NAME: \LAND PROJECTS\20180324-GLENEAGLE FIL 2\DWG\ROADWAY\03524-RDWAY-FIL2.DWG  
 PLOT DATE: December 4, 2018 6:43 AM BY: MIKE

VR-18-018

GLENEAGLE SUBDIVISION, FIL #2

STONE EAGLE PL PLAN AND PROFILE

STONE EAGLE PL
 PLAN AND PROFILE

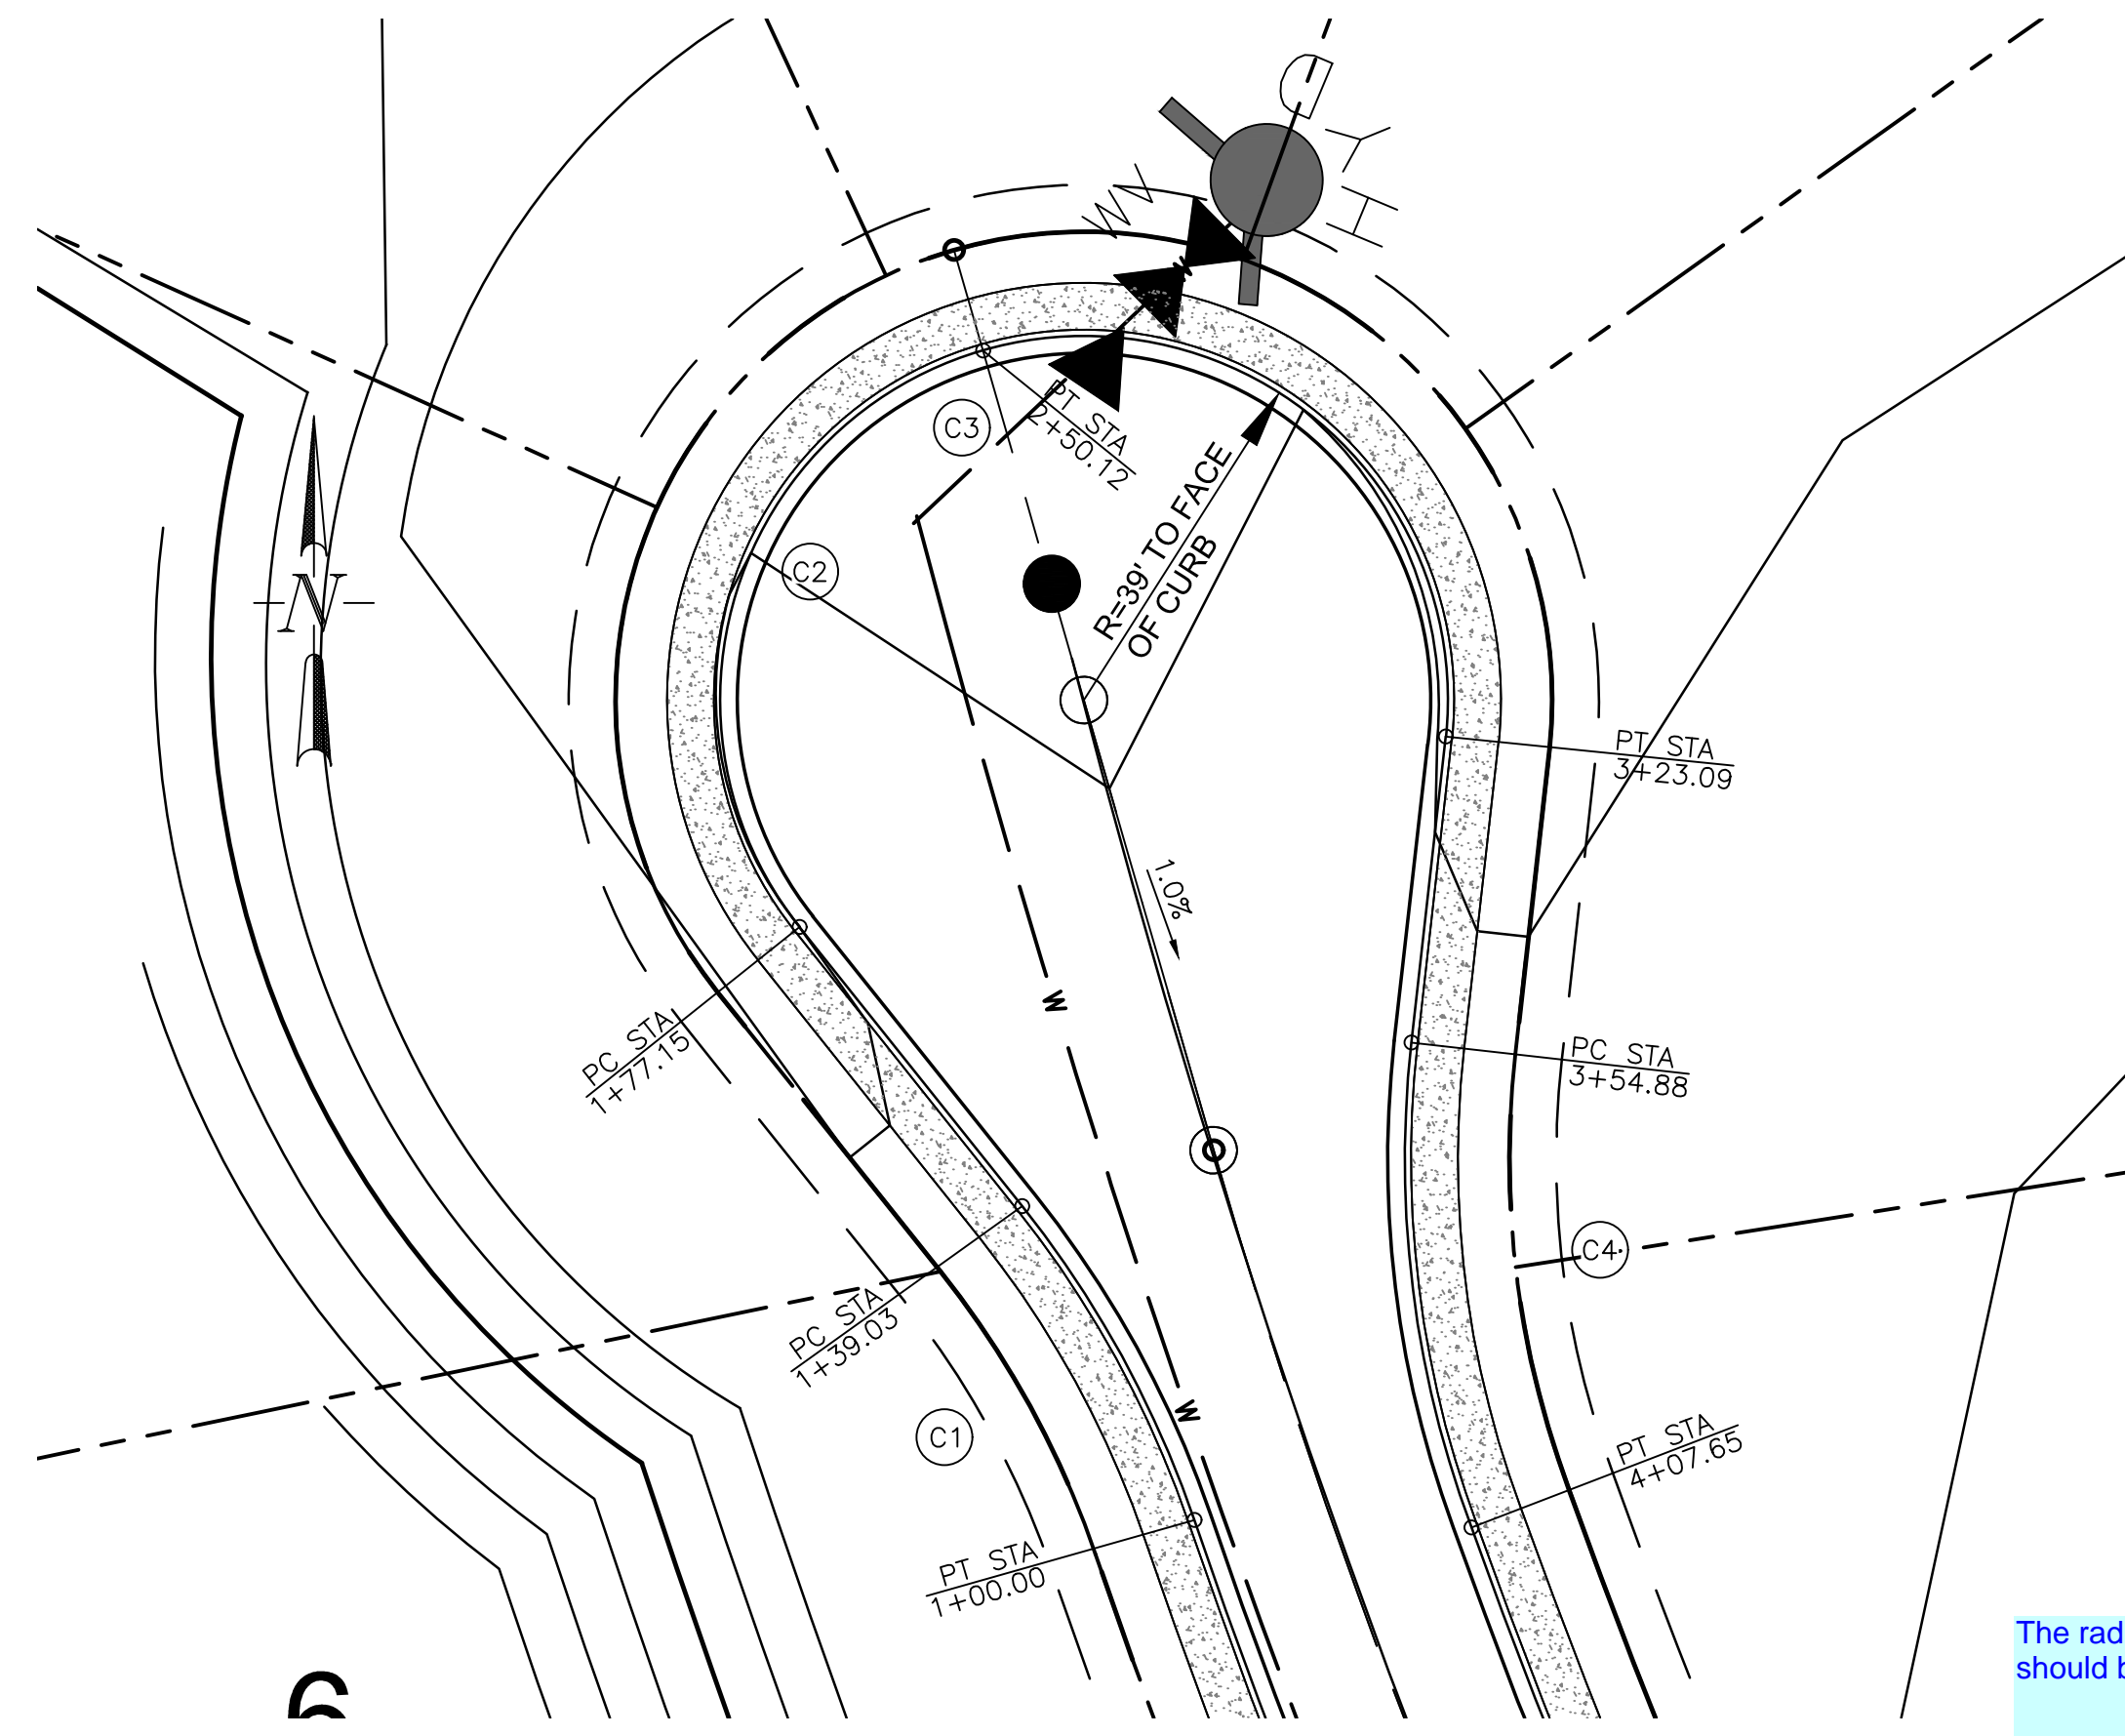
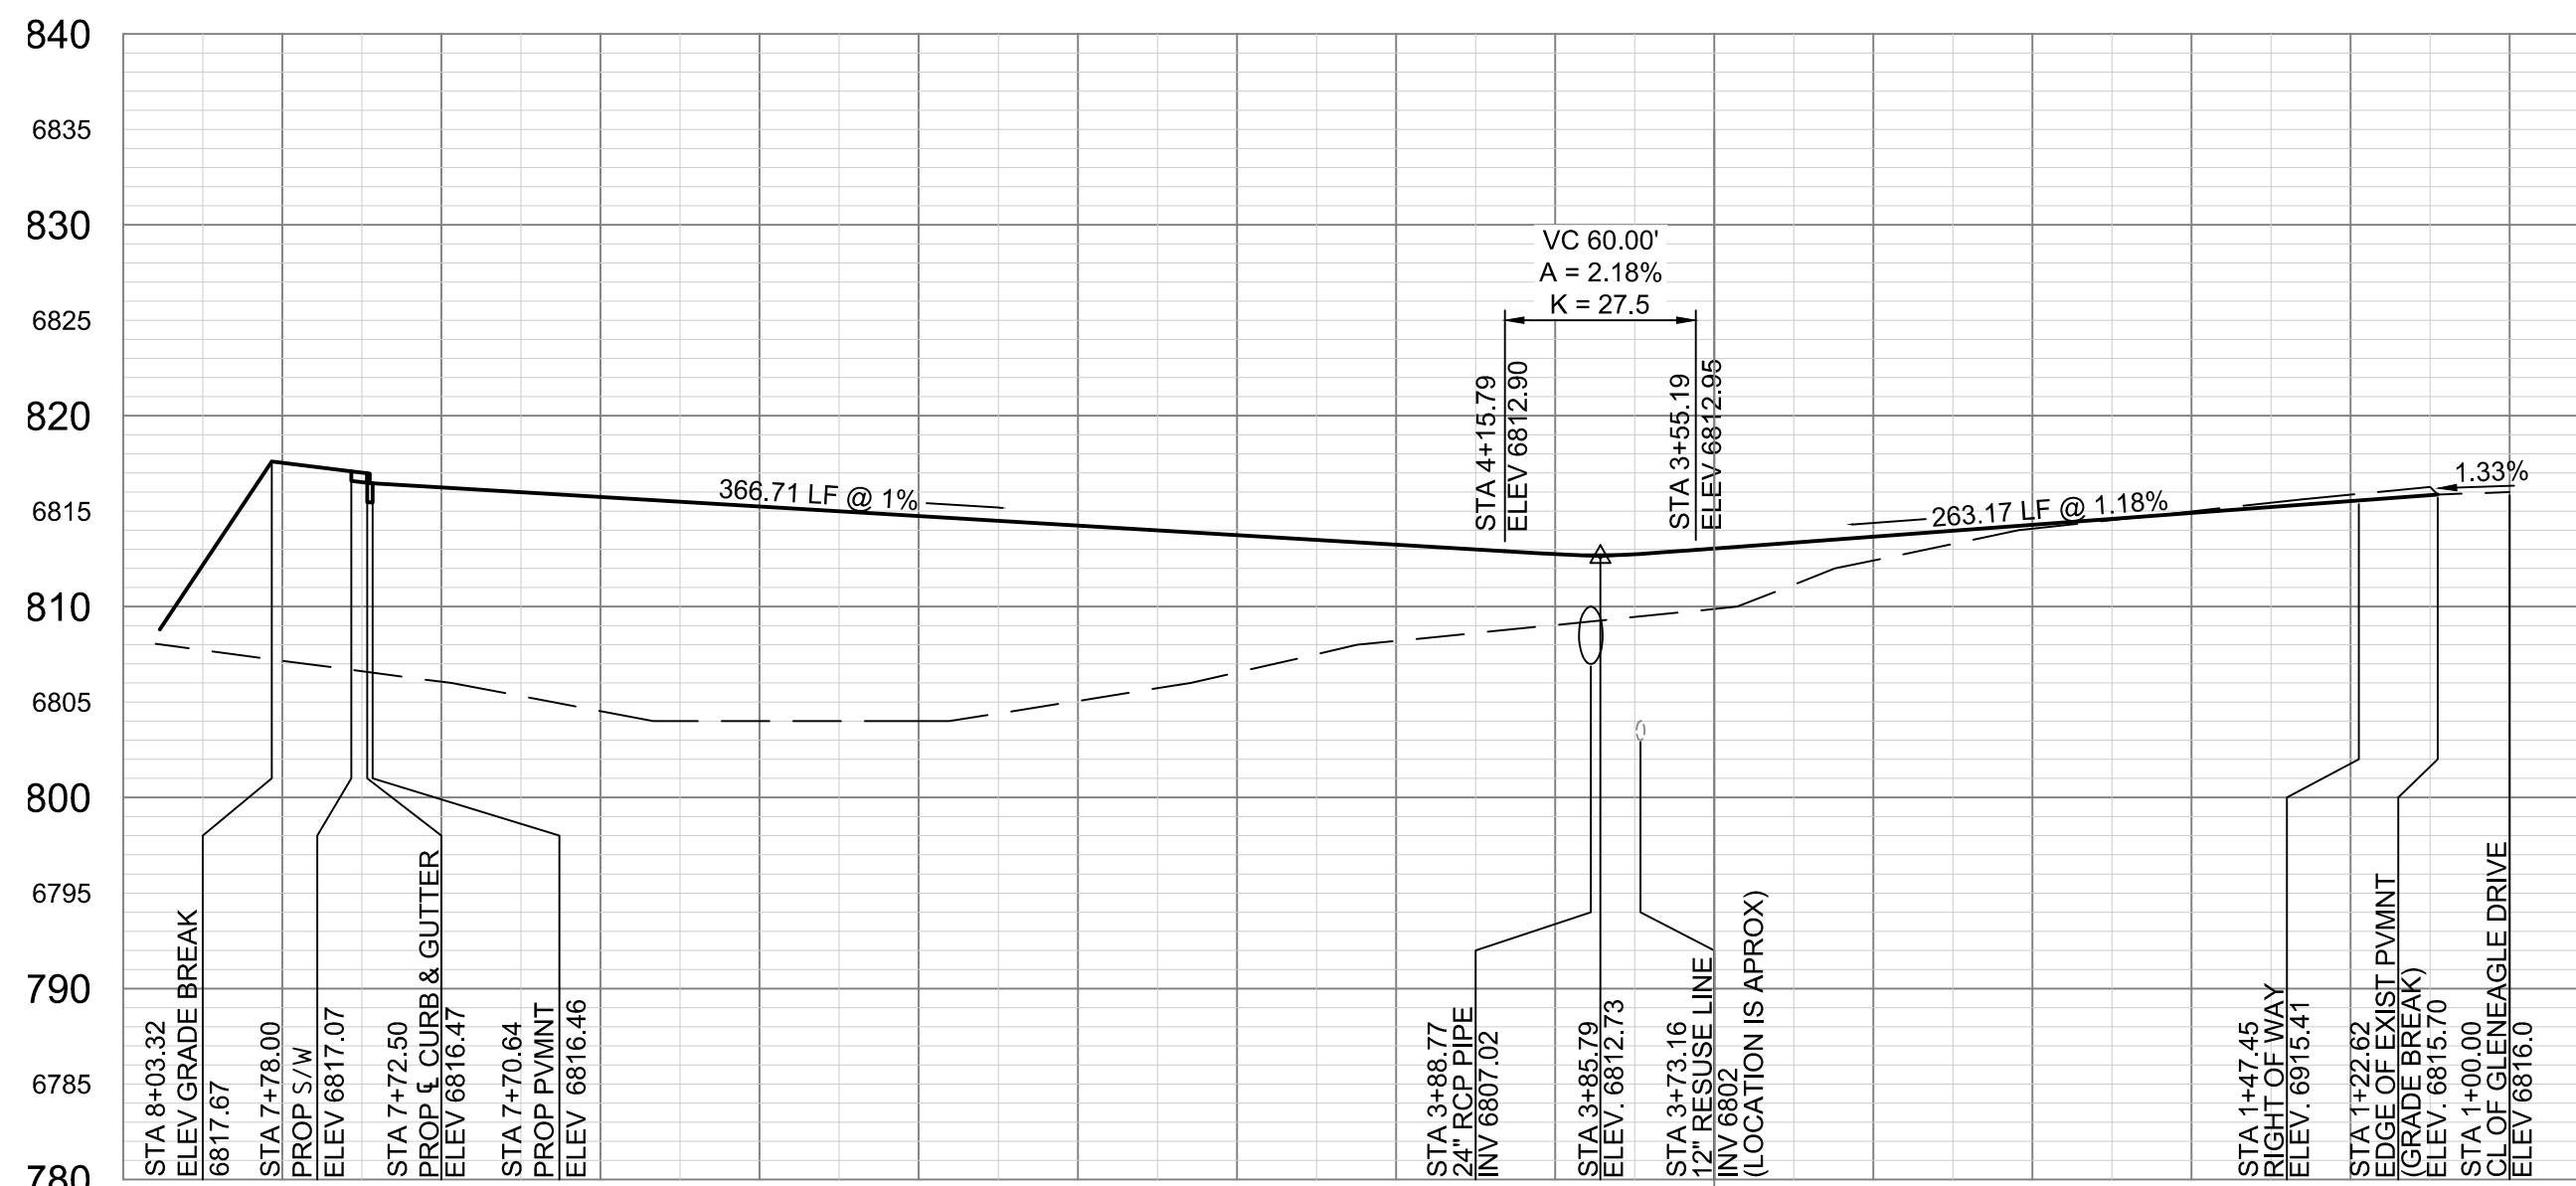
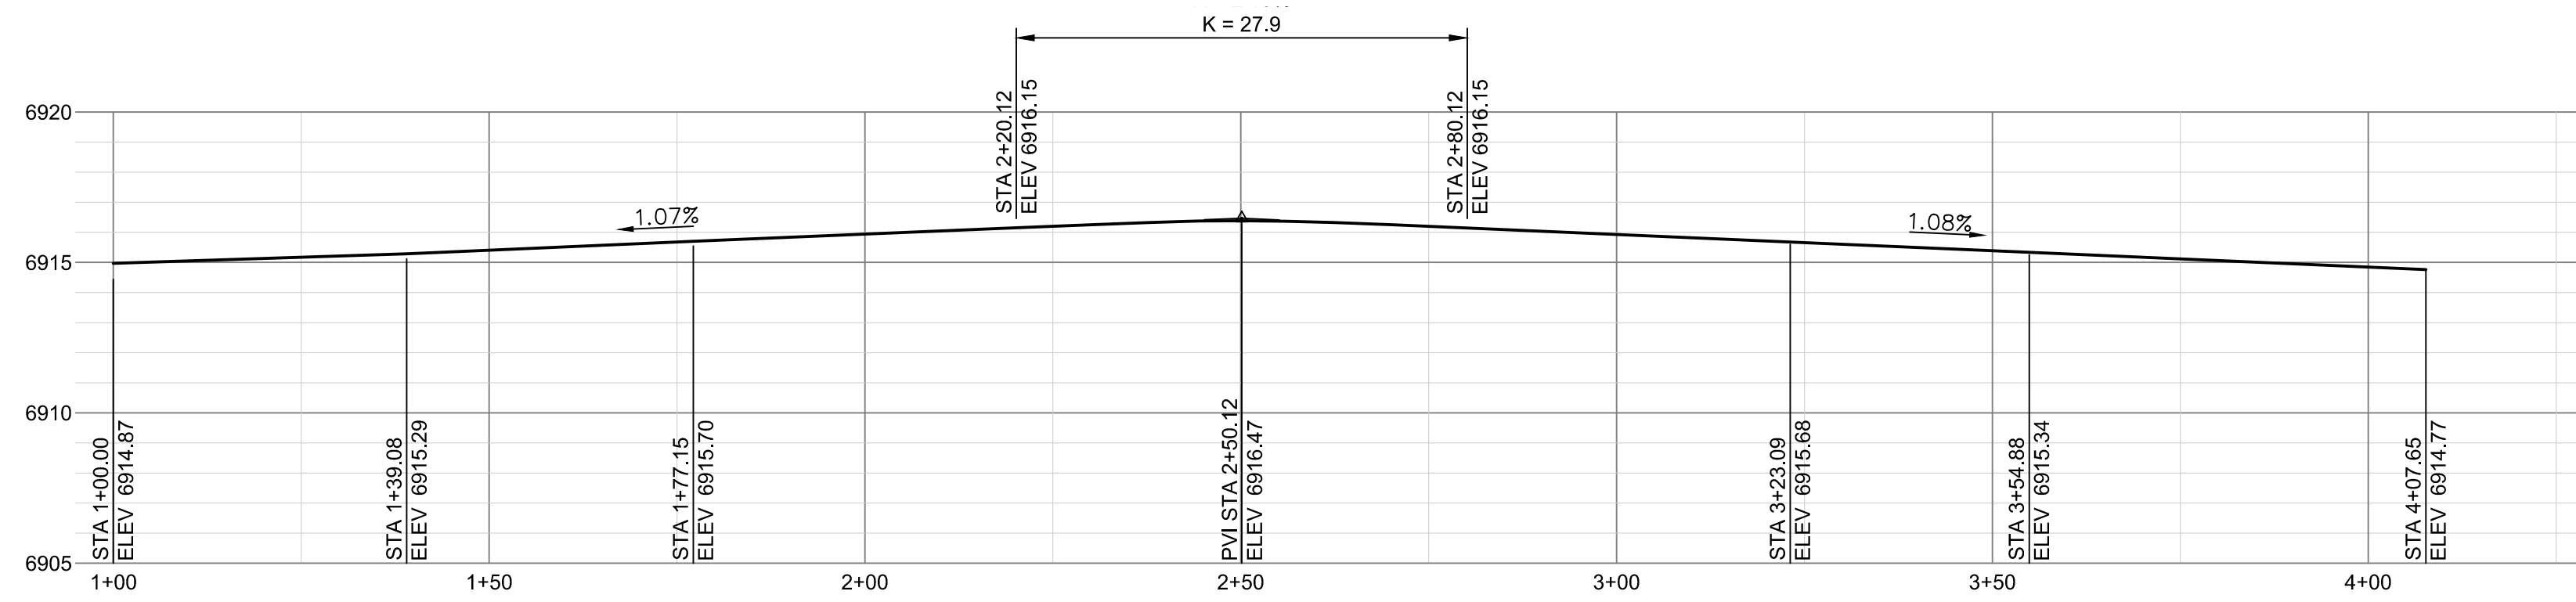
Change to El Paso County standard curb inlets.

El Paso County Criteria ECM Figure 2-31, requires a minimum radius of 45 feet for a cul-de-sac.

Revise, two sets of dimensions occupy the same space. Also a portion of the text has been cut off.
